William Simcock  
Kirklees Metropolitan Borough Council  
Development Management

**Our ref:** RA/2023/145899/05-L01  
**Your ref:** 2023/91441

**Date:** 18 June 2025

**CHANGE OF USE AND ALTERATIONS TO FORMER CHURCH (B8-STORAGE) TO 9 RESIDENTIAL UNITS (C3) AND FORMATION OF CAR PARK (LISTED BUILDING WITHIN A CONSERVATION AREA) (AMENDED PLANS SUBMITTED). 31 CHAPEL HILL, LINTHWAITE, HUDDERSFIELD, HD7 5NJ**

Drawing:  
 Proposed  
 Site Sections

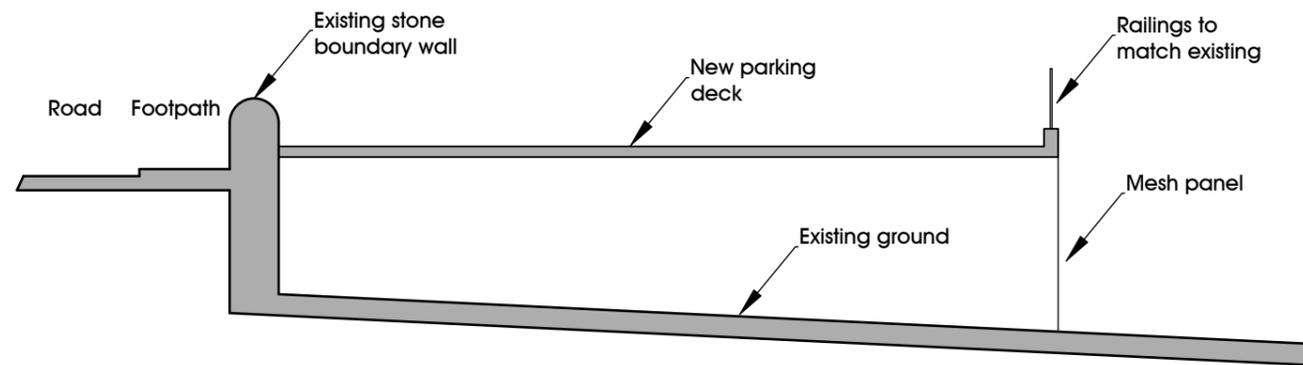
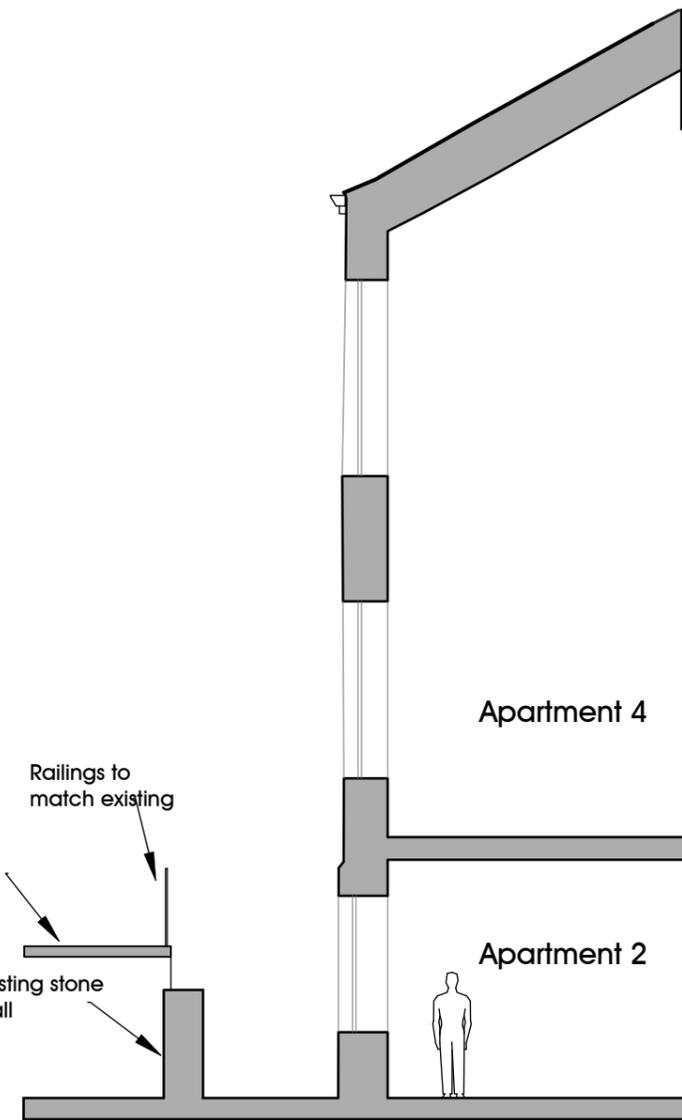
We note that the 'Elevated car park deck sections Rev P03' drawing (dated 28/05/25) appears to conflict with the 'Elevated car park deck plan Rev P02' drawing (dated 28/05/25). The former suggests the structure will not impose loadings on the culvert however the latter fails to make clear whether foundations are proposed directly on top of the culvert position. The applicant must provide evidence that the proposal will not impose additional loading on the culvert structure for us to find the proposal acceptable. As things stand, the information provided is unclear and potentially contradictory.

The applicant should clarify on the plan drawing where the foundations for the structure will be located and what these are. This needs to be clearly demonstrated through the submitted drawings, so we can fully understand where loading from the structure may impact the culvert.

The applicant must demonstrate that unrestricted access to the culvert will be maintained despite the proposals. This is necessary to ensure any required maintenance works to the structure can be carried out.

SECTION D-D THROUGH CULVERT

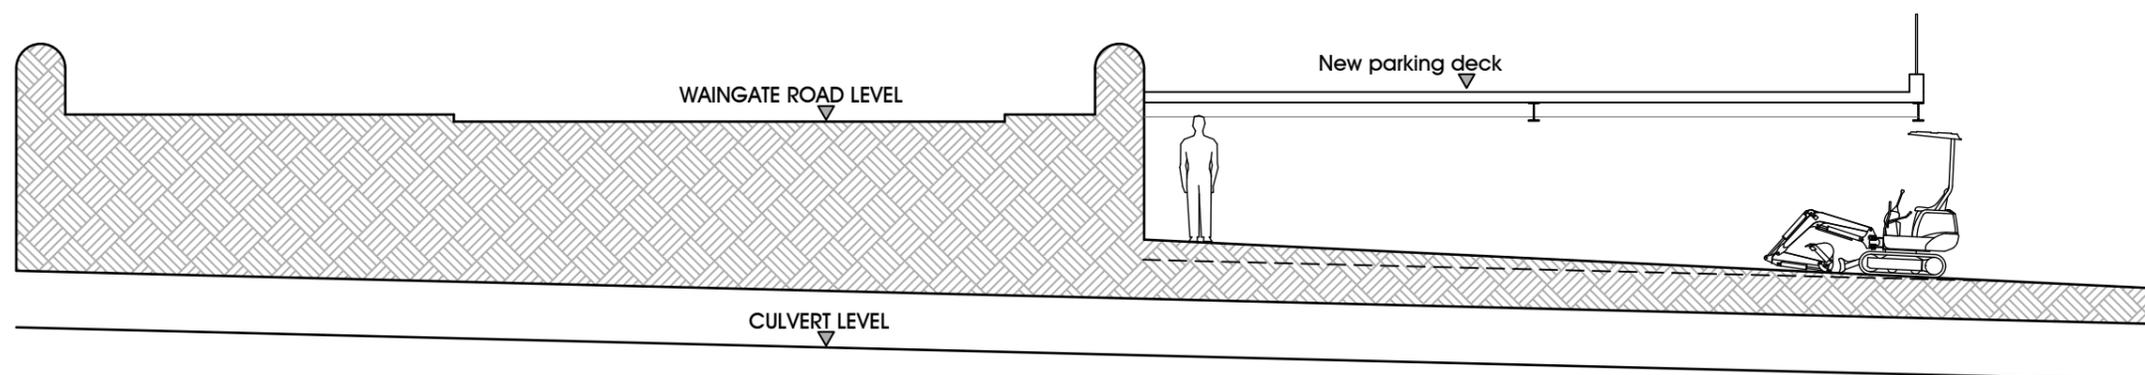
The applicant may potentially consider whether it is possible to provide car parking at existing ground level without the need for a deck. The applicant will still be required to show that unrestricted access to the culvert can be maintained, and that the structural integrity of the culvert will not be compromised by the proposals.
